From: [Rory Toomey](#)
To: [Phillip Rossington](#); [Georgia McKenzie](#)
Cc: [Troy Uleman](#); [Andrew Harvey](#); [Zoe Gleeson](#); [Vijay Prabhu](#); [Guy Pinkerton](#)
Subject: RE: Alexandria Health Centre - Design Integrity Panel Endorsement
Date: Friday, 7 June 2024 10:35:44 AM
Attachments: [image002.png](#)
[image003.png](#)
[image004.png](#)
[image005.png](#)
[image006.png](#)

RE: Alexandria Health Centre DIP Review RTS

Drawing Title
GROUND FLOOR GENERAL ARRANGEMENT PLAN
Drawing Status
STAGE 2 SSDA

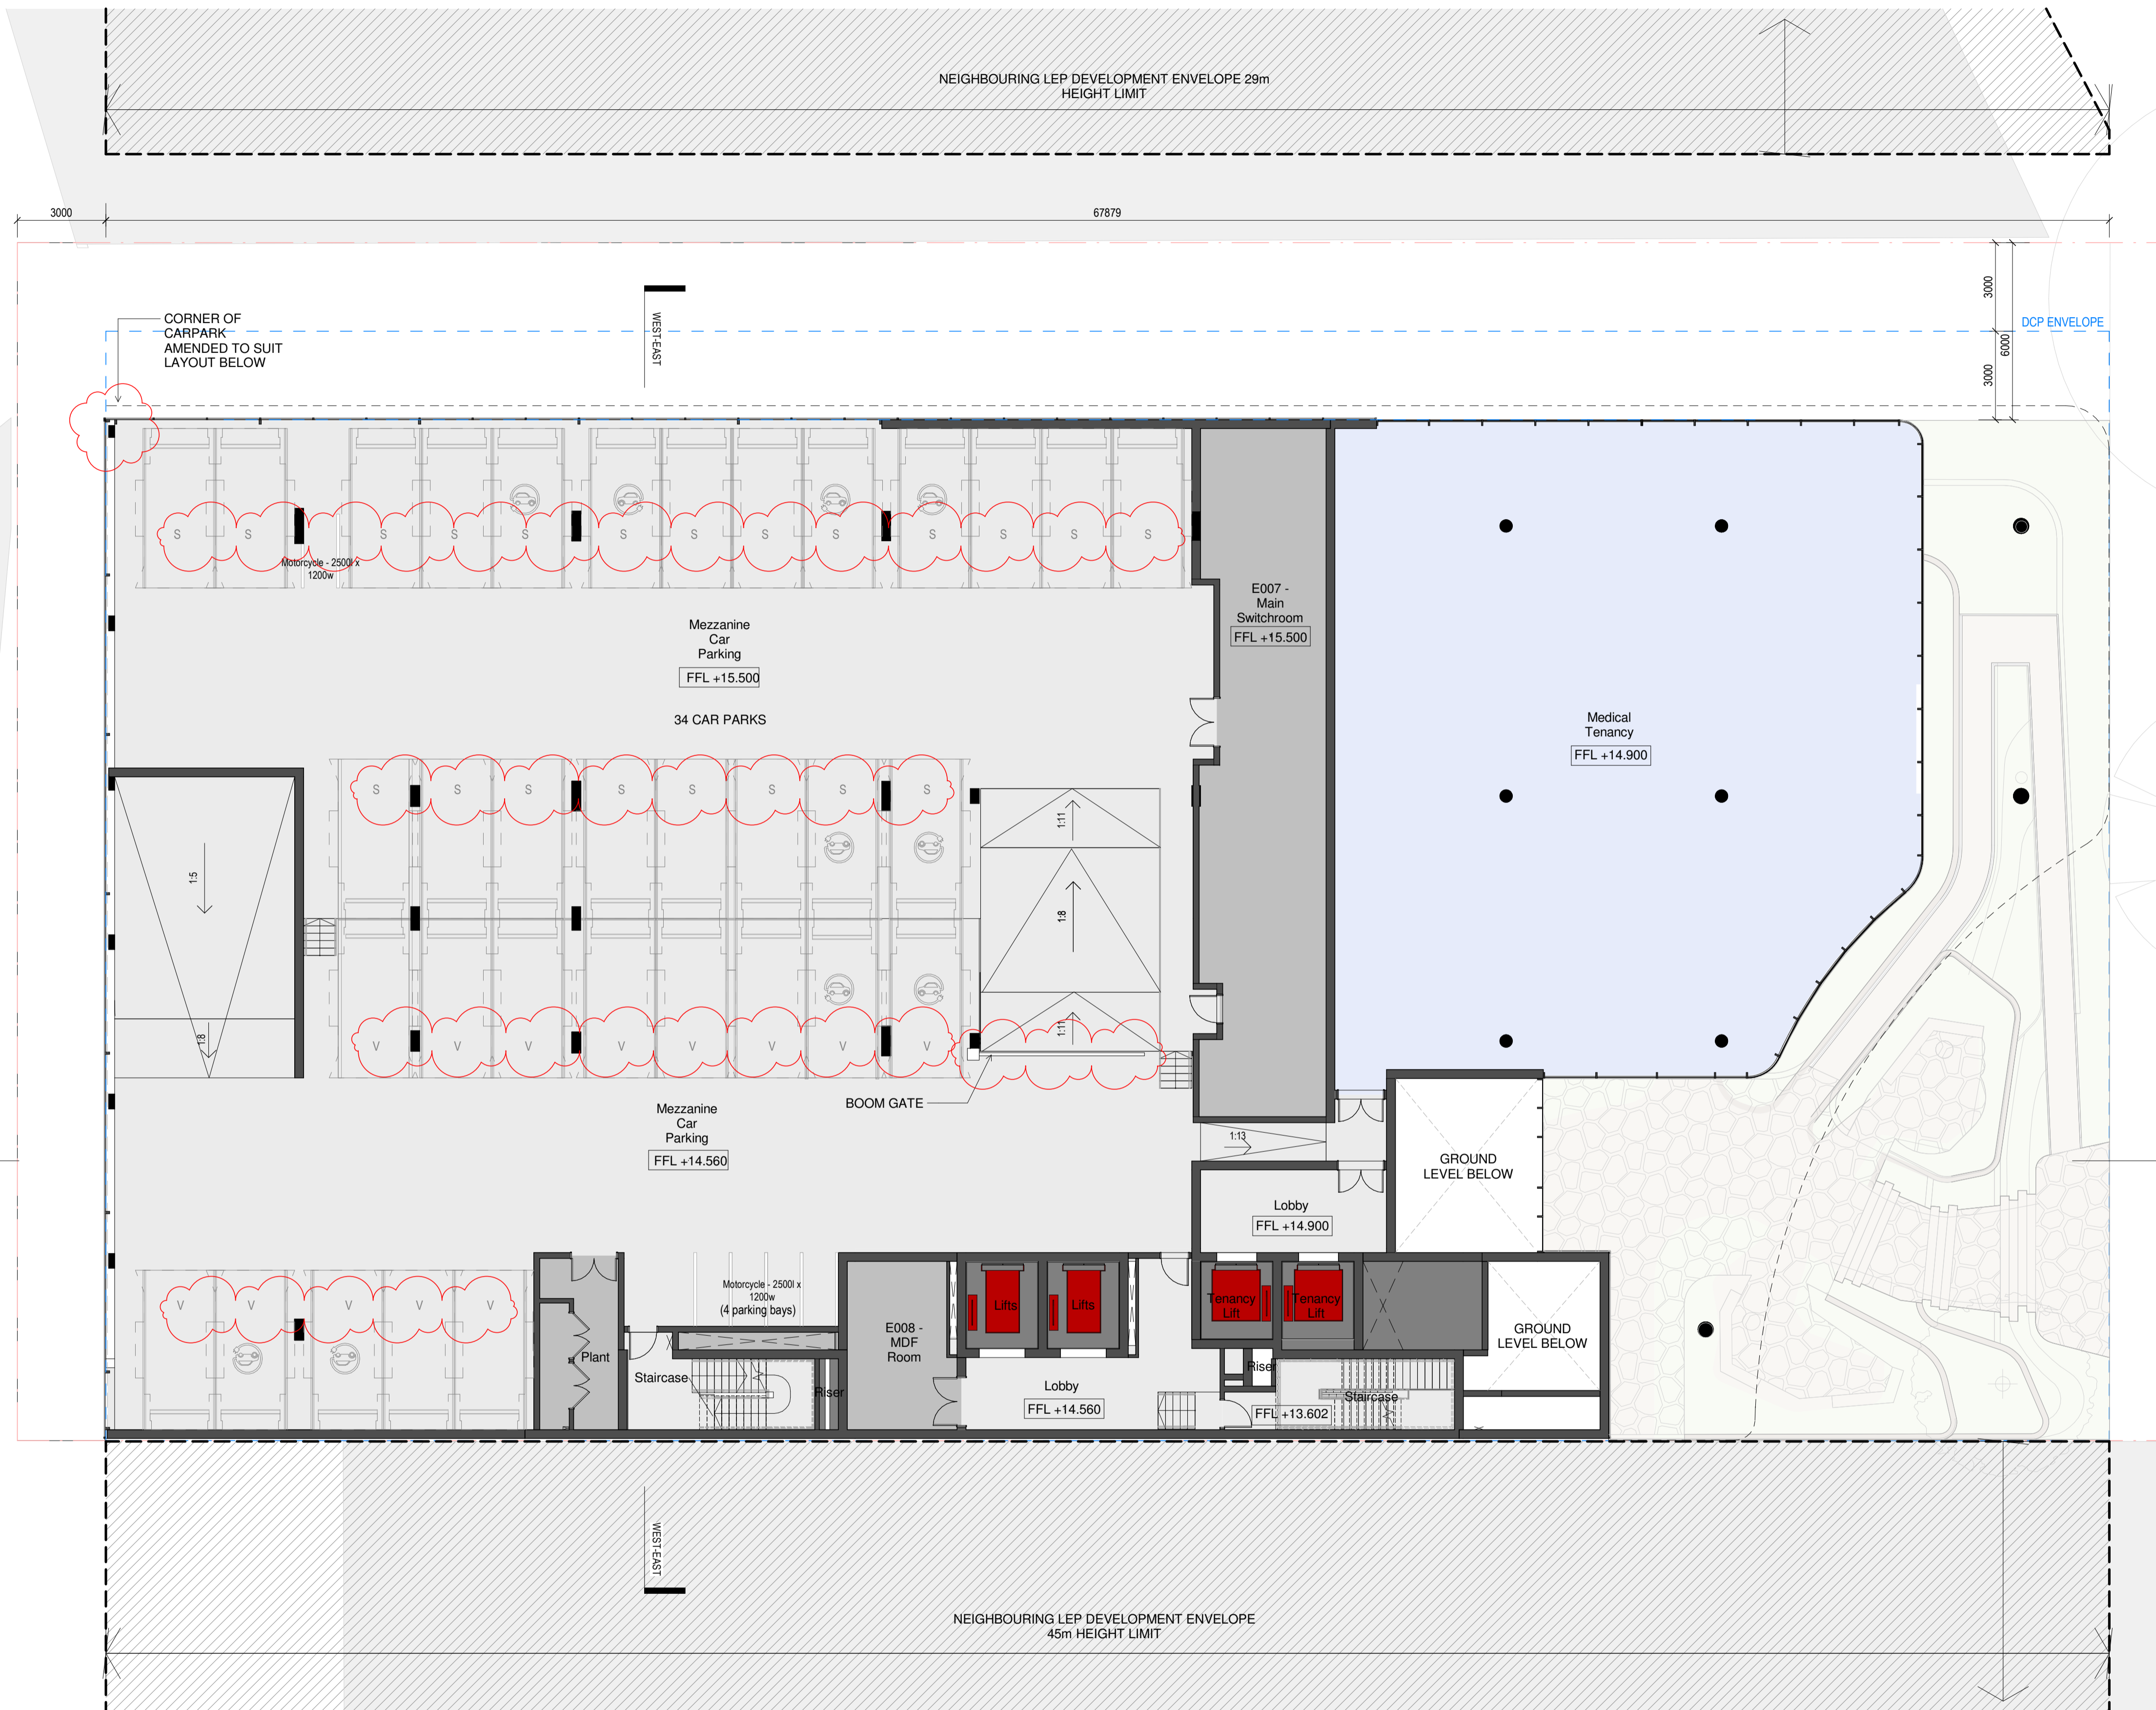
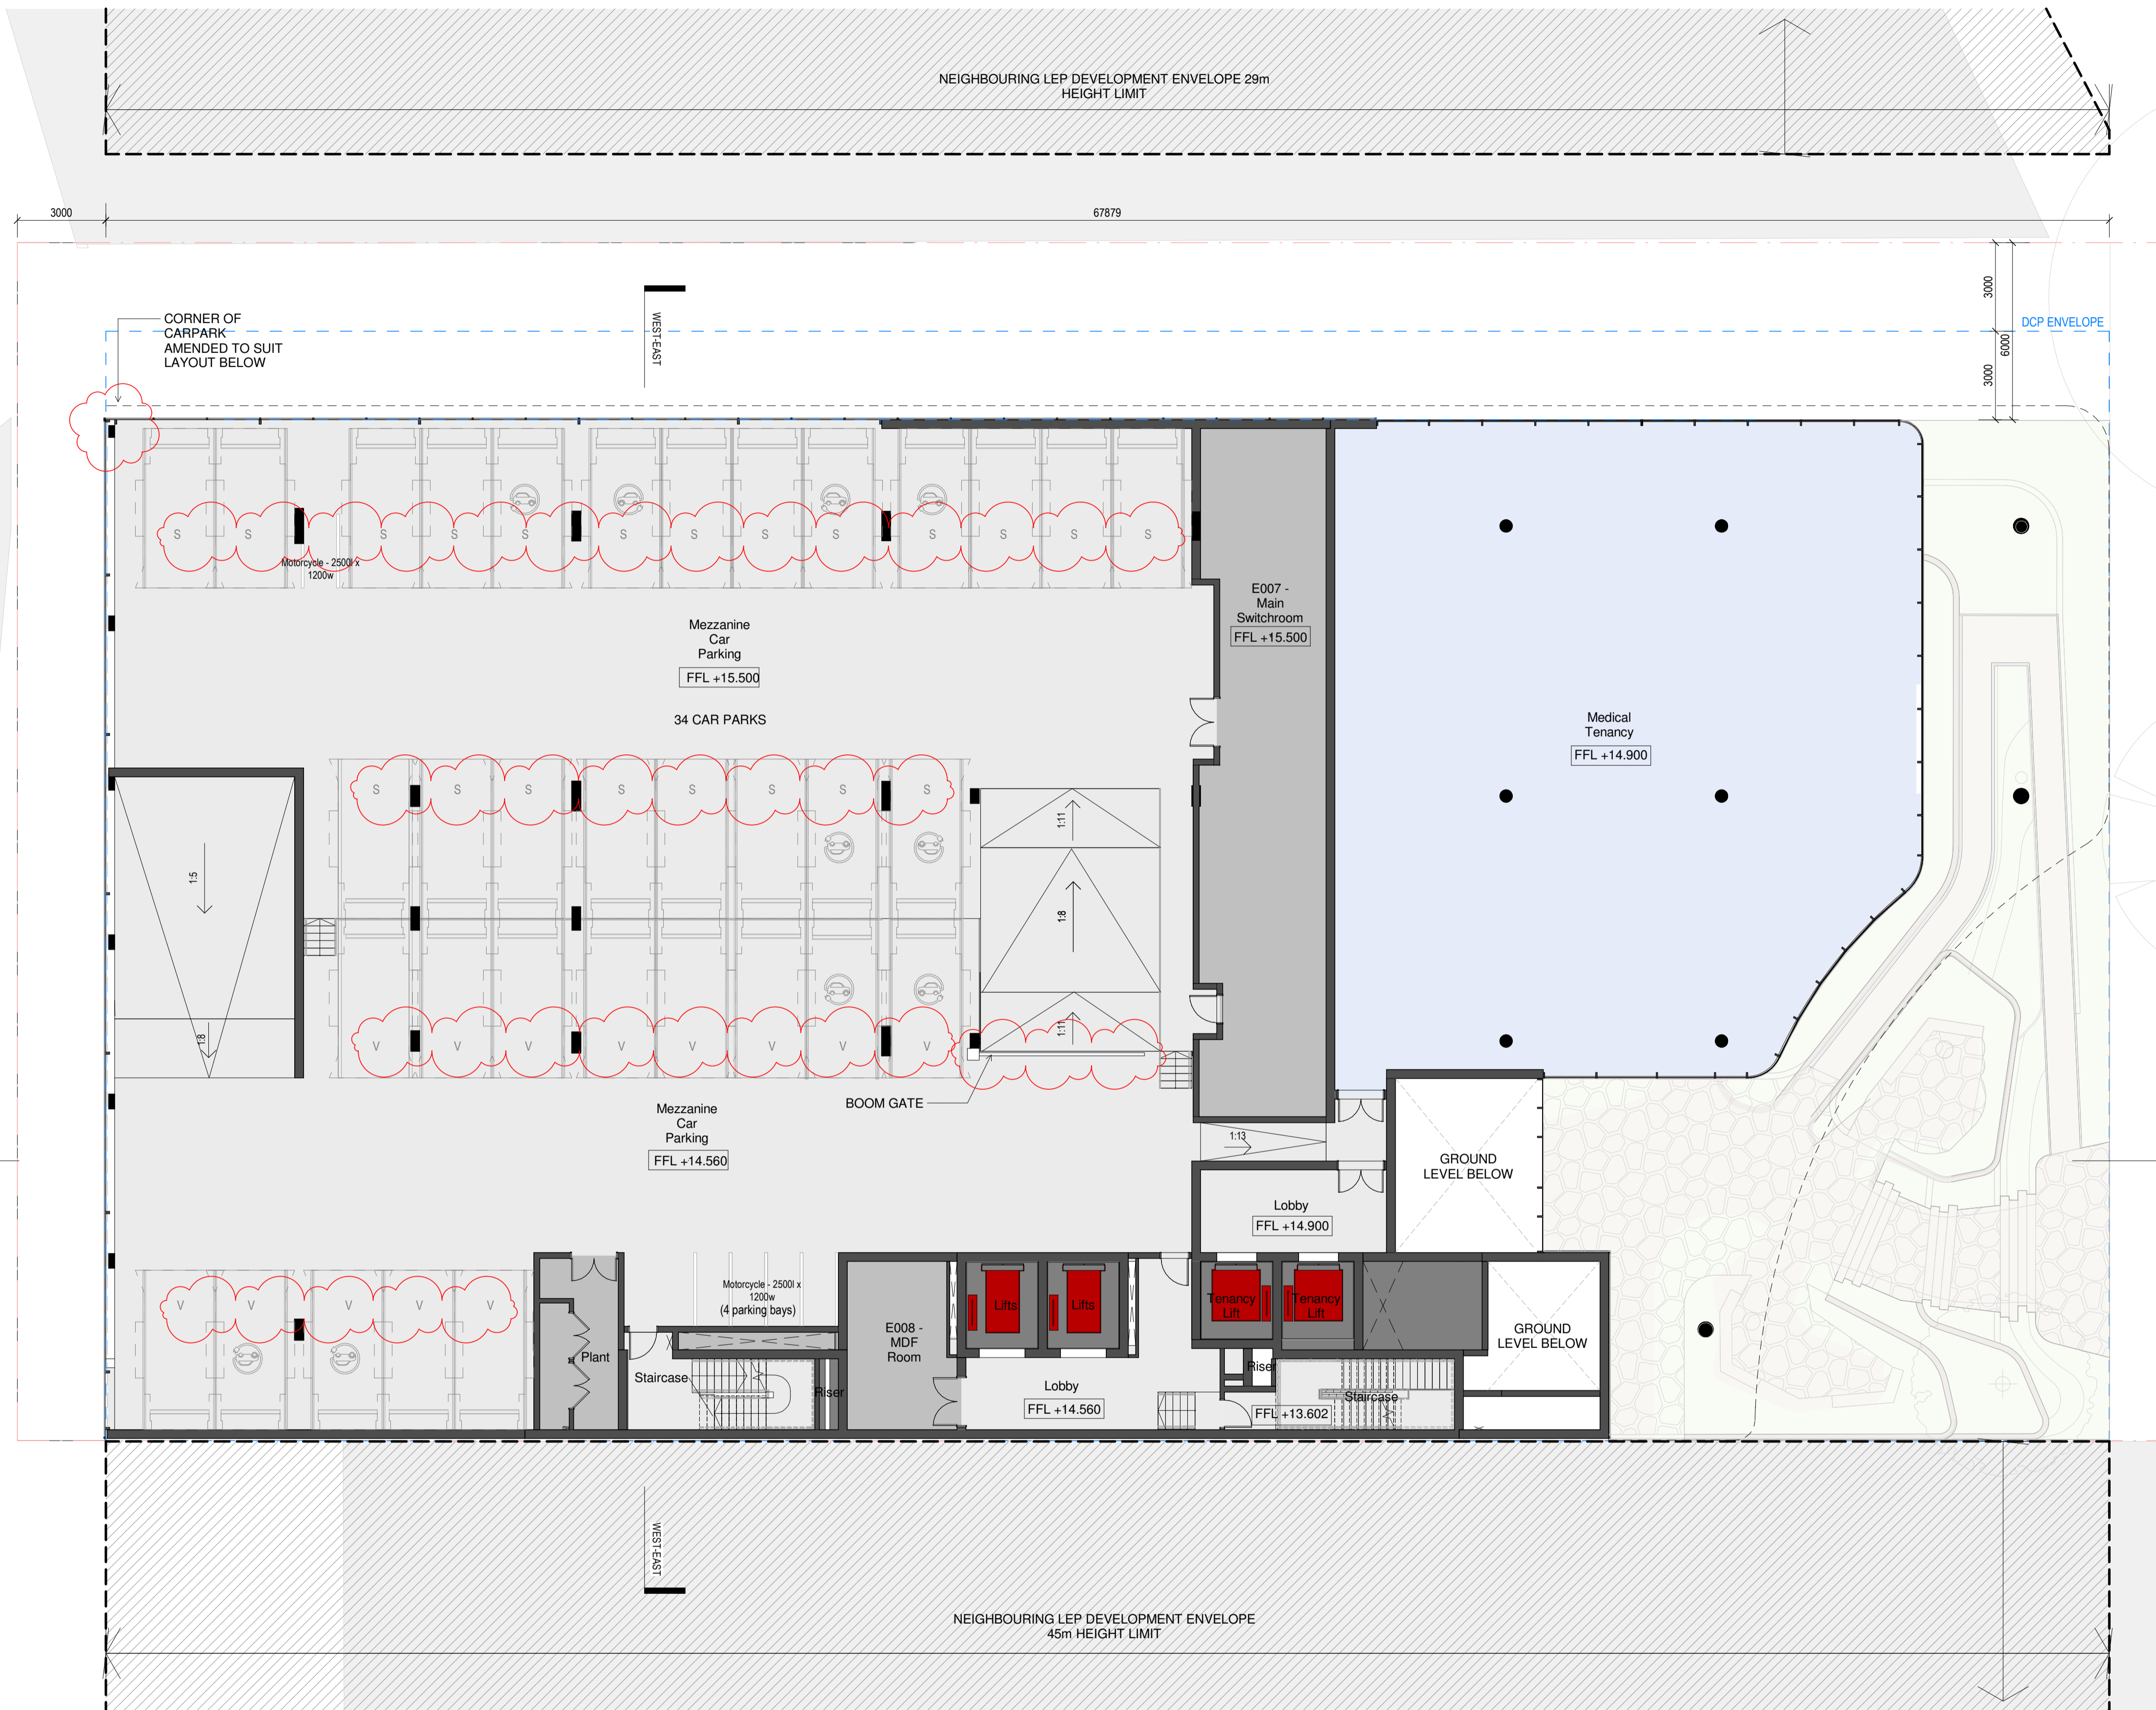
- Number and allocation of parking spaces
- Function, location and treatment of grease arrestor
- Legibility, safety and wayfinding for patient drop off space
